Consultation Response from KC, Highways Development Management
2026/91738 6, Station Road, Skelmanthorpe, Huddersfield, HD8 9AU
Change of use from retail to retail coffee shop and bar with alcohol
Date Responded: 20 July 2026
Responding Officer: Sheila Henley
Responding Ref: 17-22/41

Plan Ref: Block Plan; Proposed Floor Plans.

Scottys Bar

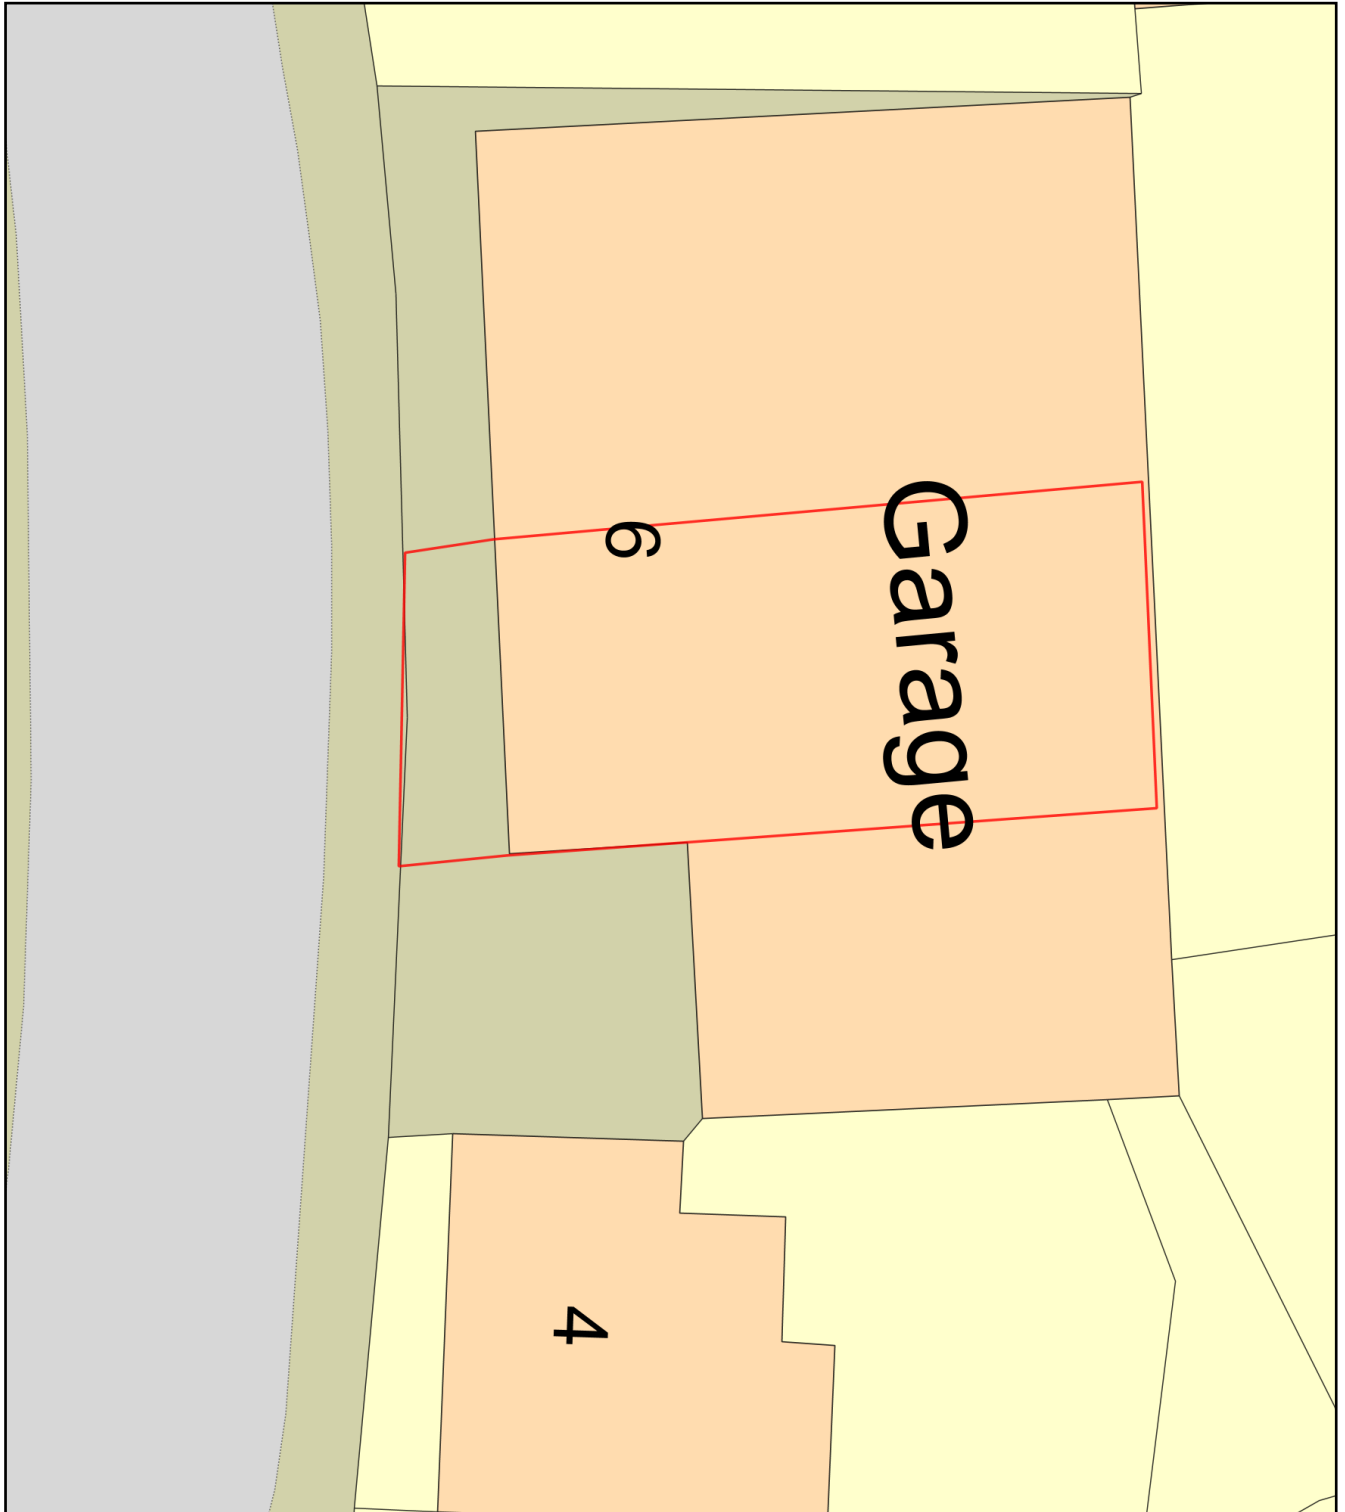
Access and egress are to be retained from Station Road. These are shared with adjoining premises.

Within the proposal site, the forecourt is to be retained. This would provide space for small scale servicing of food, drink, and sundries etc, such as by a car or small van. Bin storage is not identified but could be accommodated within the premises or forecourt for kerbside collection.

There is no on-site parking. Kirklees does not have parking standards and seeks to ensure that parking provision is appropriate to the needs of a development and not reduced below a reasonable level. For those Councils that do have parking criteria, the number of car parking spaces for café bars is based on an assessment on the amount of customer floorspace, number of staff as well as level of accessibility and proximity to the town centre. Typically, higher levels of accessibility require operational levels of parking and none for customers. These circumstances are found at this proposal site; it is accessible and has a relatively small customer floor area. Whilst, it is proposed to have four staff FTE's, they are unlikely to be on site all at the same time due to shifts and may not all travel by car. For those that do travel by car, there is limited on-street space available outside the units where this proposal site is to be located, and any parking would be on a first come first served basis but is constrained by the road width. Parking and waiting restrictions apply nearby too.

Accordingly, the proposal is acceptable from the highway perspective and no objection is raised.

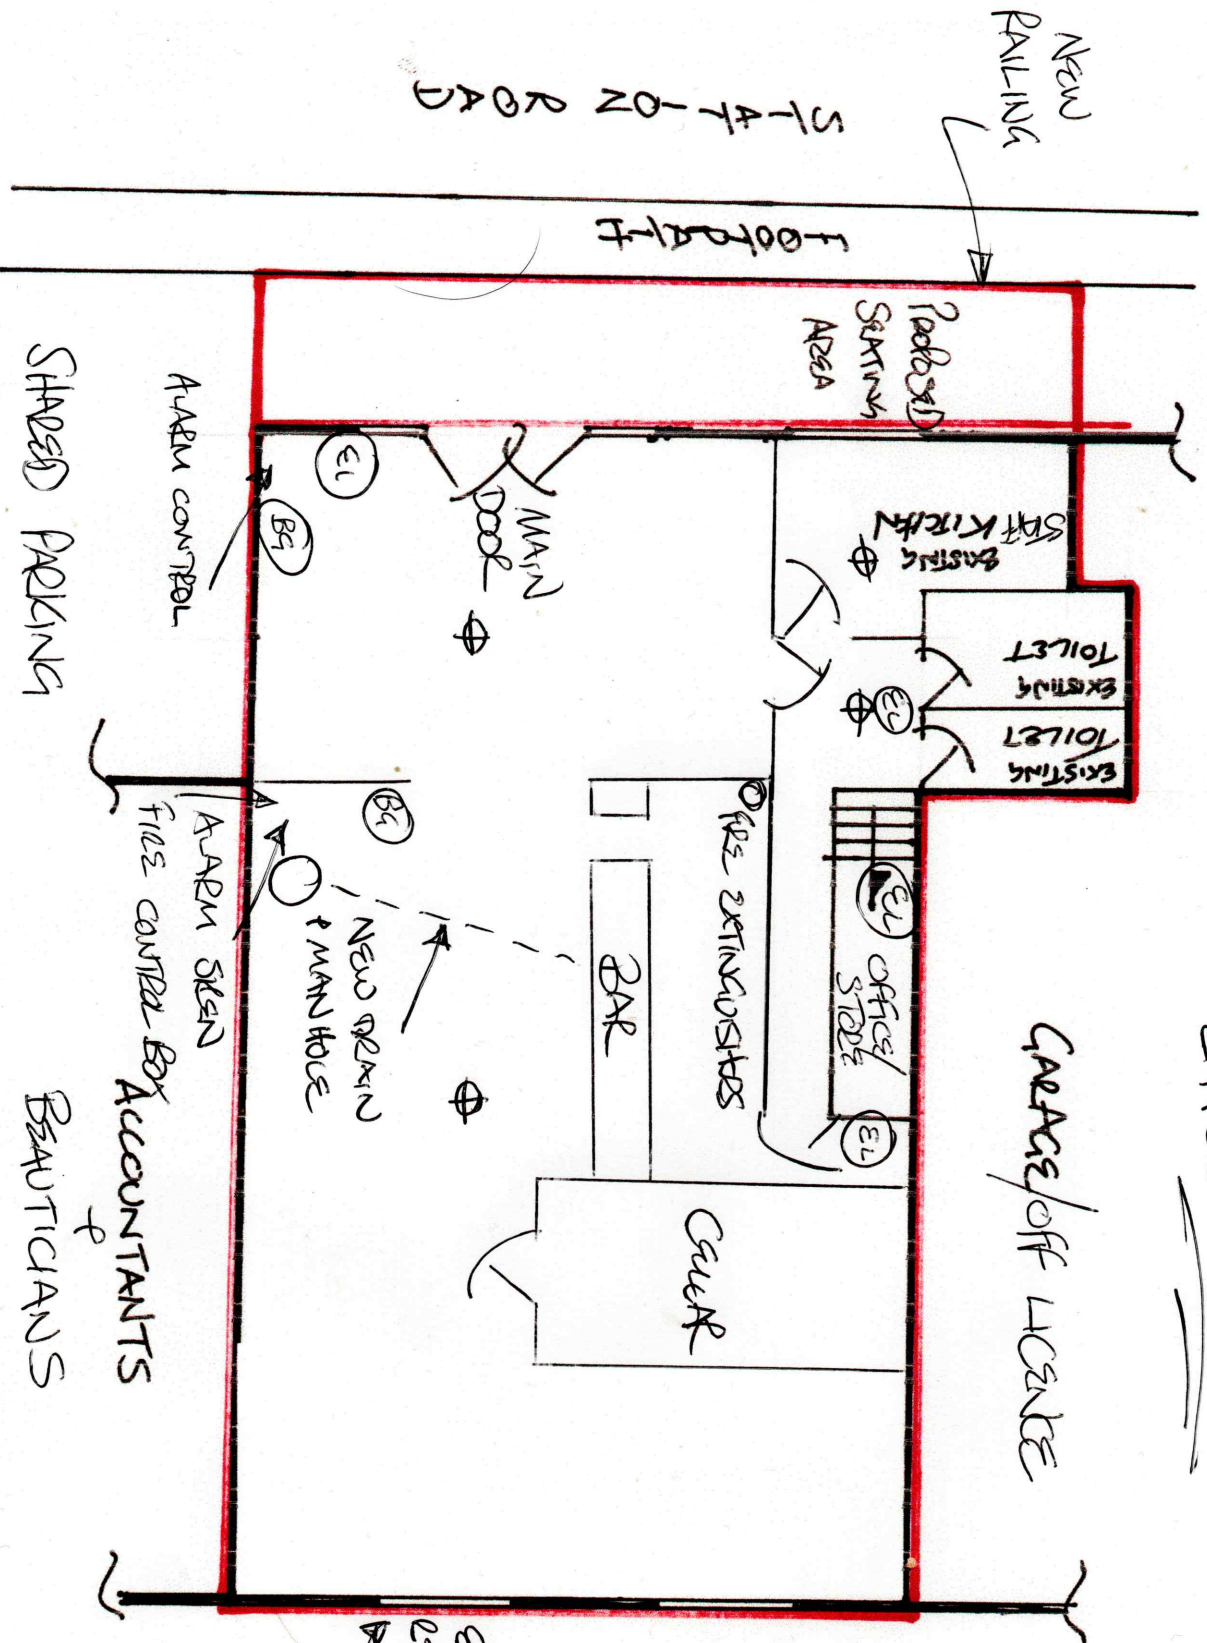
The installation of cycle parking would further support policy LP20 and encourage mode choice and Active Travel, but there appears to be insufficient space for storage within the site for staff as well as outside for visitor use.
